CITY OF ALBUQUERQUE

October 7, 2013

**Re: 8801 Glendale Ave NE, Grading and Drainage Plan
Engineer's Stamp Date 10-4-13 (B20D021)**

CULVERT INLET DETAIL

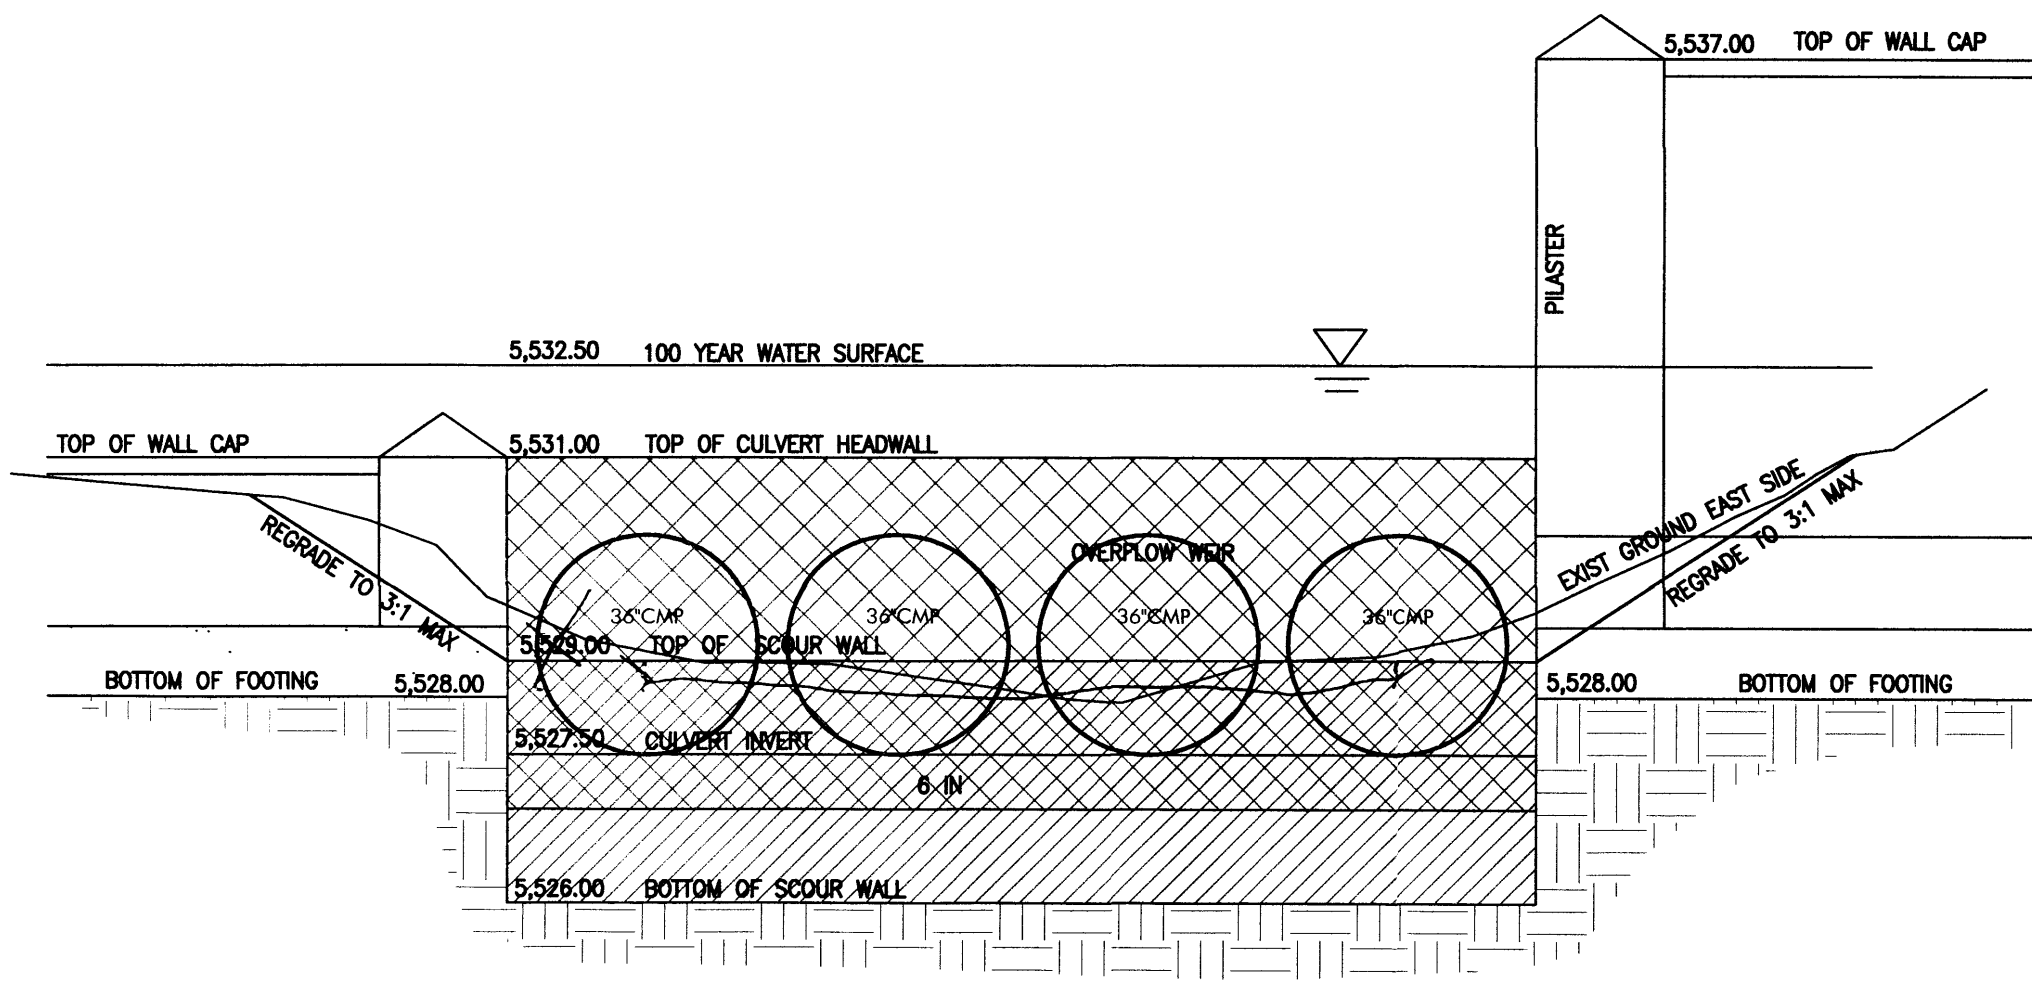
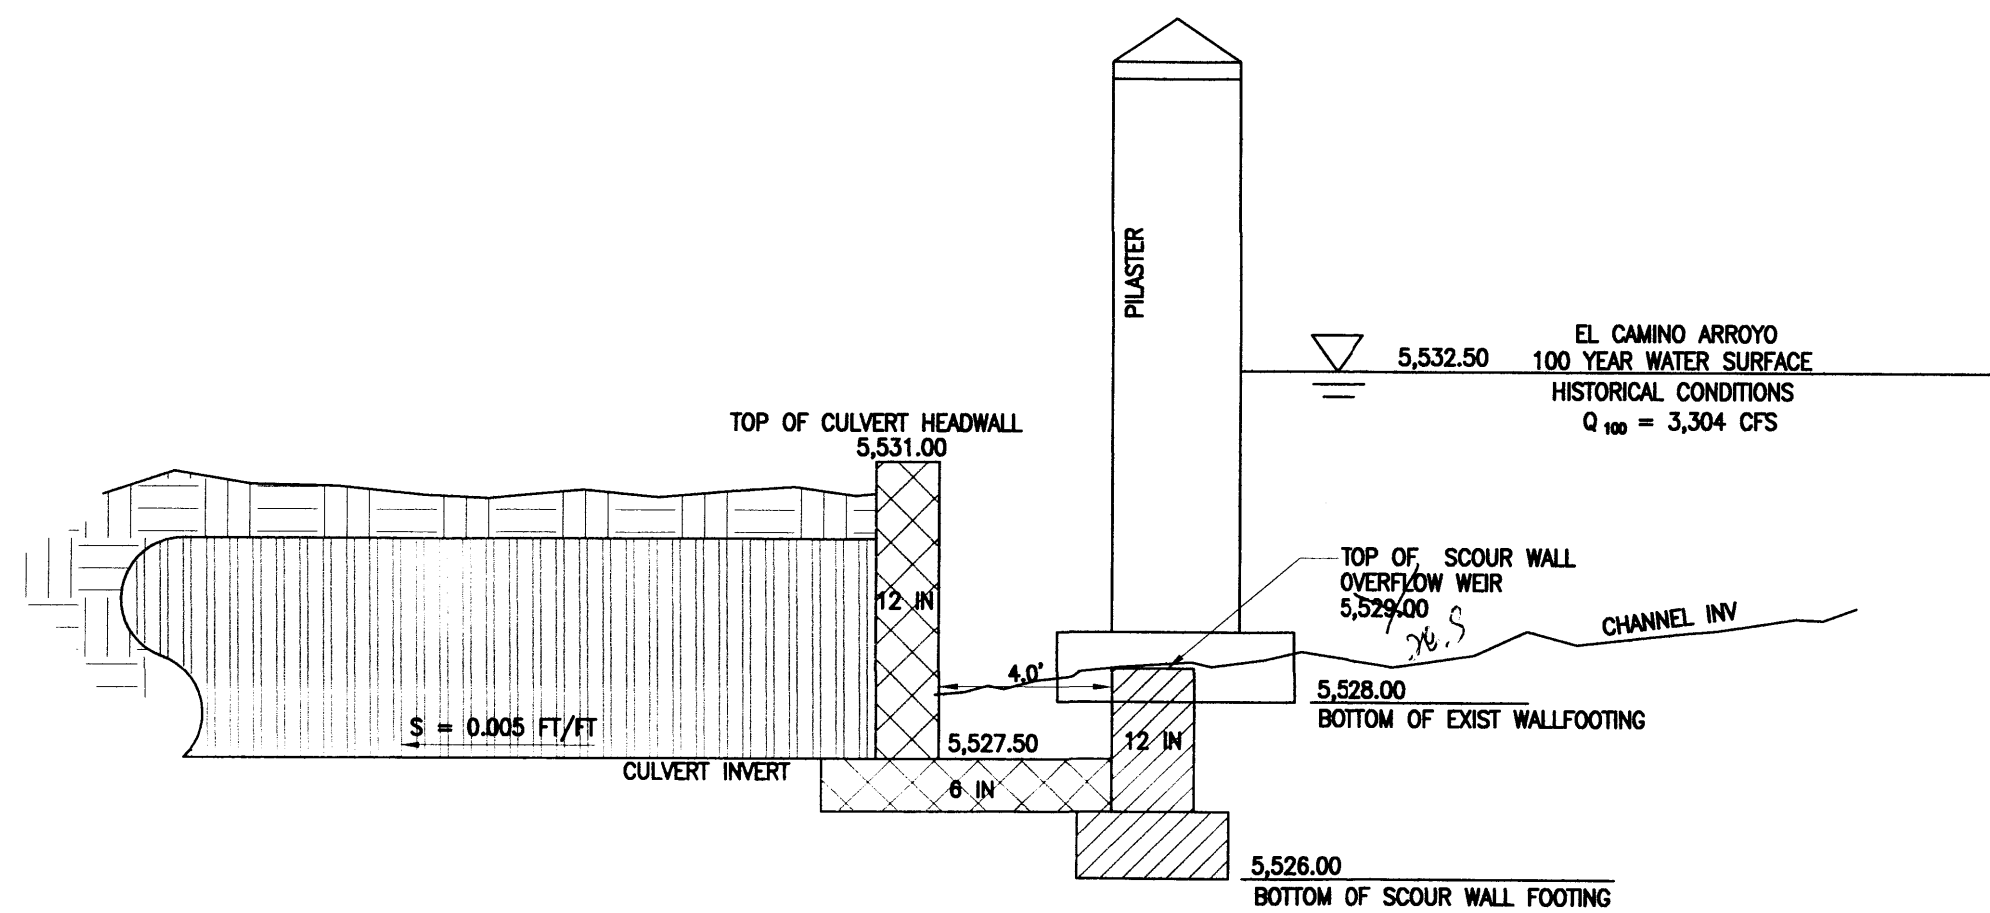
a. Revise the culvert inlet Detail on Sheet 2 of 2 to show the existing arroyo invert (approximately 27.5) and the predevelopment arroyo invert (approximately 28.6). The "Exist Ground East Side" grade is shown too high.

4. The compaction note is in a place where compaction is not required. A more appropriate location would be the culvert inlet detail or section B-B.

6. The culvert headwall should be tied into the concrete below it so it doesn't fall over due to the load above it.

8. Revise the inlet weir INV from 30.00 to 28.5 or just remove the note since the Top of Scour wall elevation is the inlet weir elevation.

DRIVEWAY CULVERT SECTION B-B

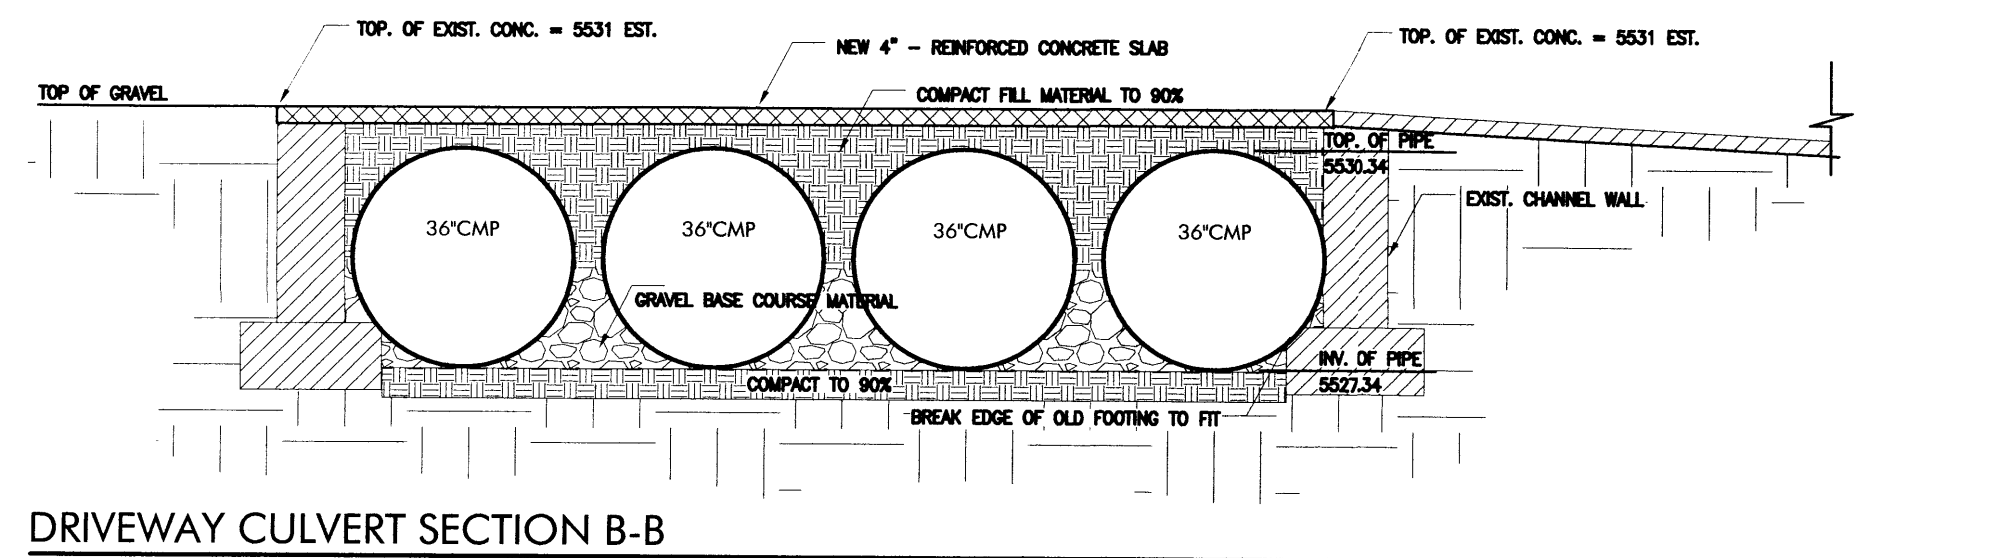
2. Show the existing driveway, vertical walls and the ground beneath the pipes in the driveway culvert section B-B. Include spot elevations for Top of Concrete on the south and north sides. There is an existing TOC of 29.03 at the southwest corner where the CMPs go under the driveway. This appears to be a conflict with the pipes.

5. The Driveway culvert Section could be omitted as it is not necessary. IF you wish to keep it, amend the minimum cover dimension to reflect the actual minimum cover.
